**WEST YORKSHIRE
POLICE**

To: Richard Gilbert Kirklees Council Planning Services	Ref: 2023/92966 Date: 26 th October 2023
--	--

Site Location: Land rear of 271 Cliffe Lane, Gomersal, BD19 4SB
Application Type: Residential Dwellings

BOUNDARY PLAN

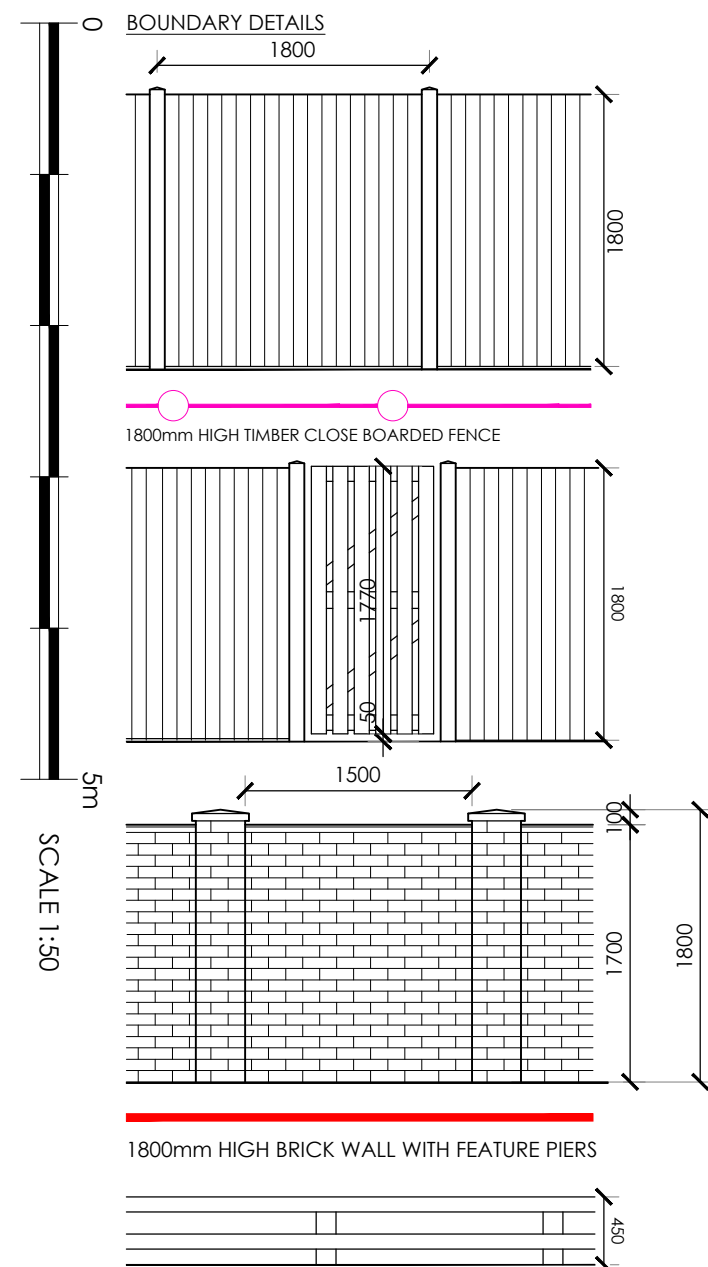
It is recommended the rear boundary treatments for each plot are to a height of 1800mm such as masonry materials, close boarded timber fencing or other durable materials. Rear plot dividers in height of 1800mm consisting of the same material as above should be installed between properties.

Access must be restricted from the front of each plot into the rear garden by installing a 1800mm high lockable gate. This gate should be positioned near to the front building line to eliminate recesses and to increase natural surveillance restricting unauthorised access.

All external facing boundary treatments **MUST** be smooth faced with no footholds or cross members to enable climbing access.

Plot dividers need to be tall and substantial enough to provide both privacy and security. Closed boarded timber fencing should be provided to a minimum 1.5m in height, and include privacy screen (a section of higher fencing) of 1.8m in height projecting out from the building for about 2m, to provide a private amenity area adjacent to the home.

Gates to the side of the dwelling that provide access to rear gardens or yards must be robustly constructed, be the same height as the fence (minimum height 1.8m) and be capable of being locked (operable by key from both sides of the gate). Such gates must be located on or as near to the front of the building line as possible.
